# CITY OF ALBUQUERQUE

January 14th, 2013

**Re: Cantata at the Trails, Grading Plan  
Engineer's Stamp Date 10/2/12 (C09/D001B)**

Sheet No.:  
**C2.04**

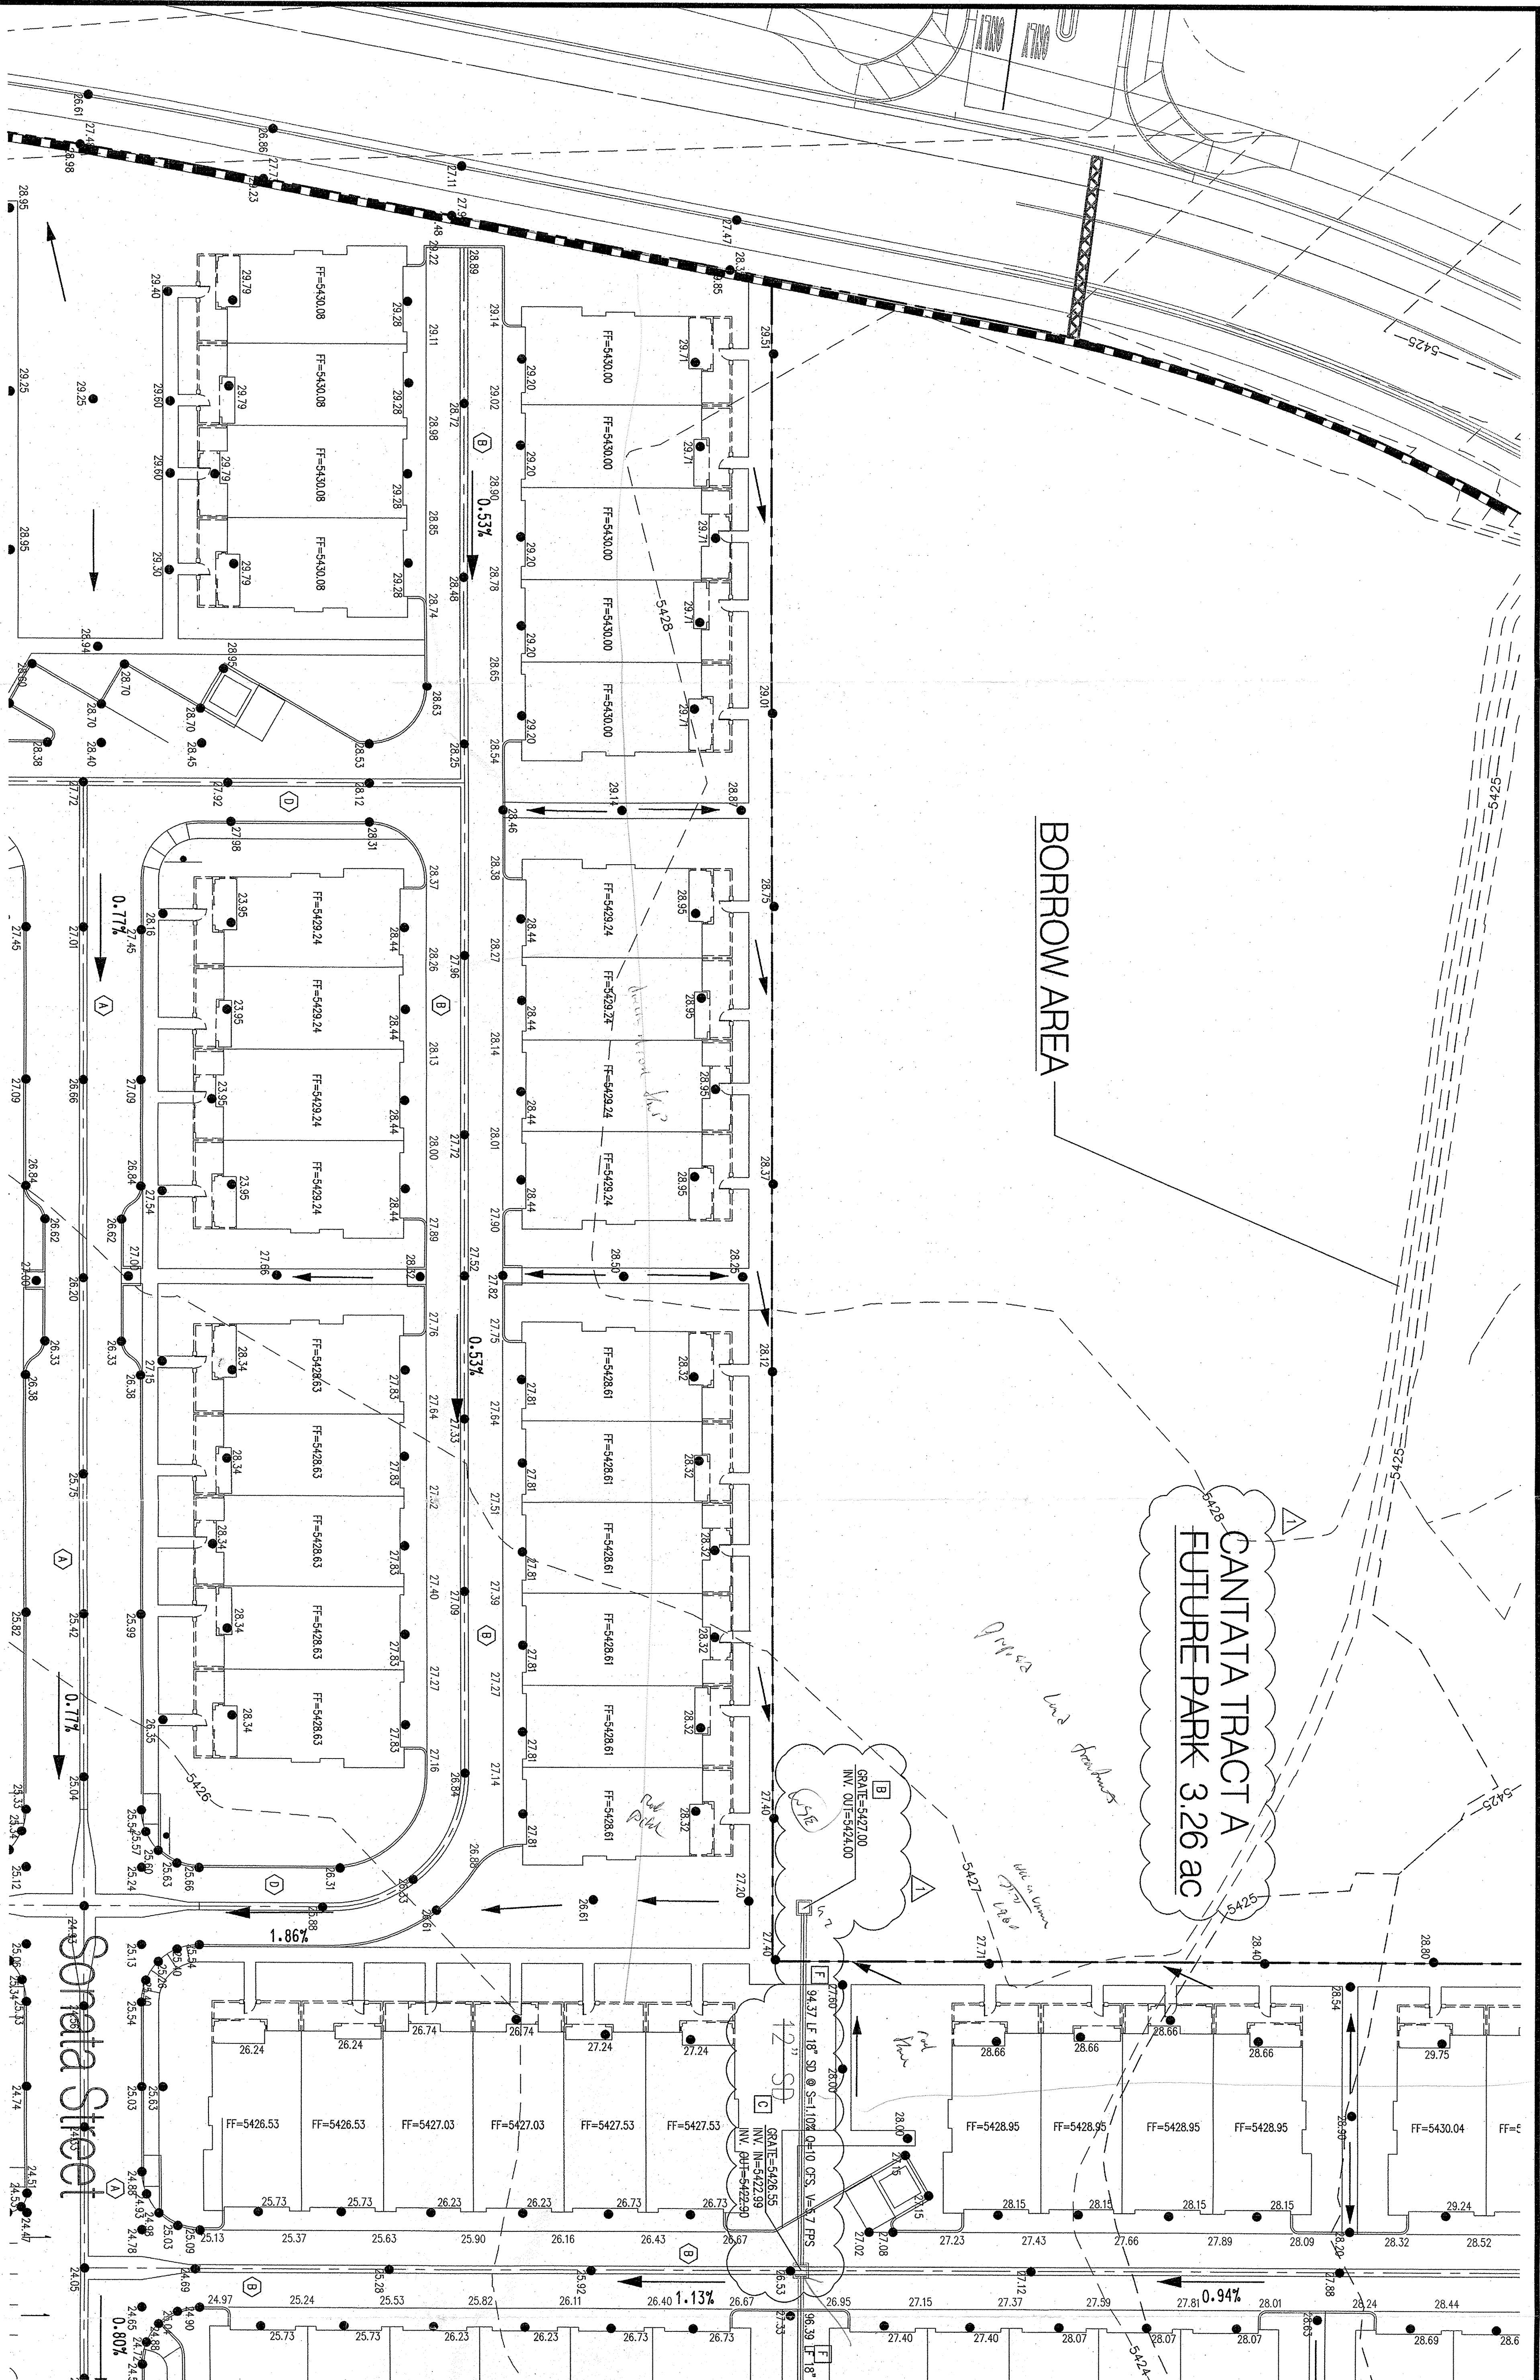
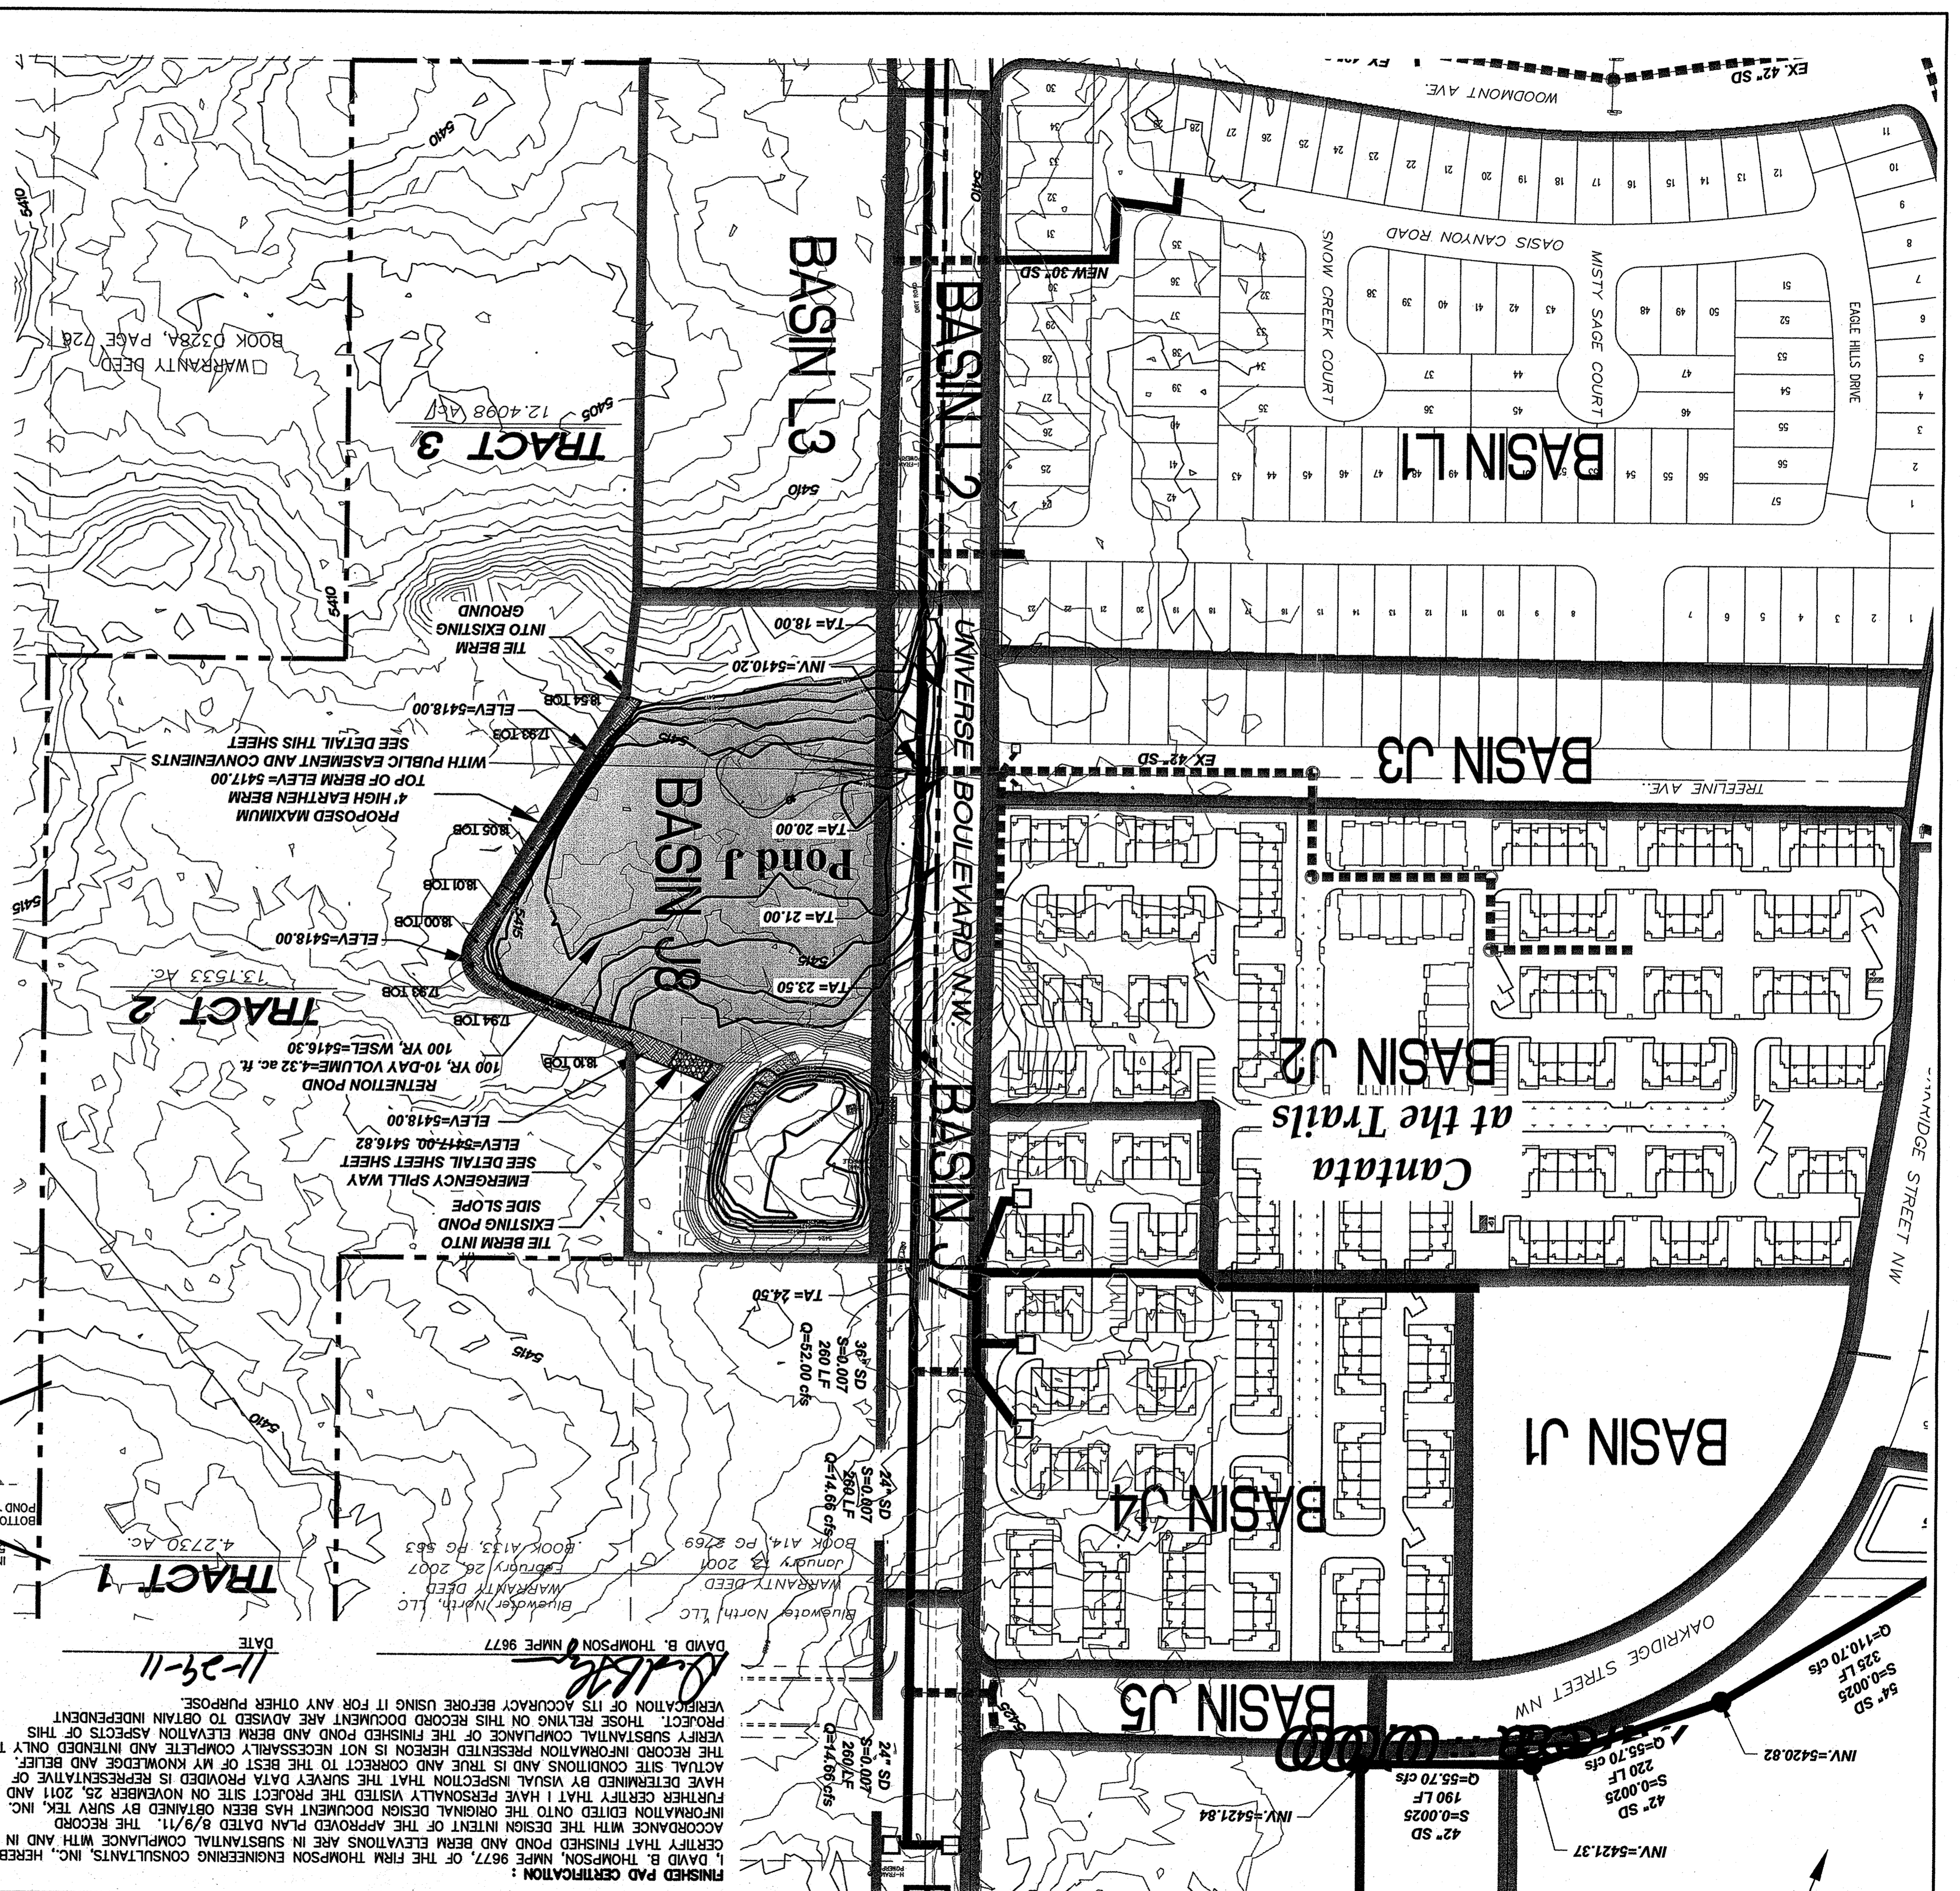
In addition, the areas adjacent to Tract A to the south and east may drain to the storm drain that extends into Tract A or drain south through the landscape area near the southeast corner of Tract A.

If these areas drain into the storm drain, this may cause the storm drain to surge at inlet #3, bypassing approximately 2.5 cfs. This bypass will then drain to inlet #12.

When Tract A develops, an update to the Cantata at the Trails drainage report is required for Site Plan and Building Permit approvals.
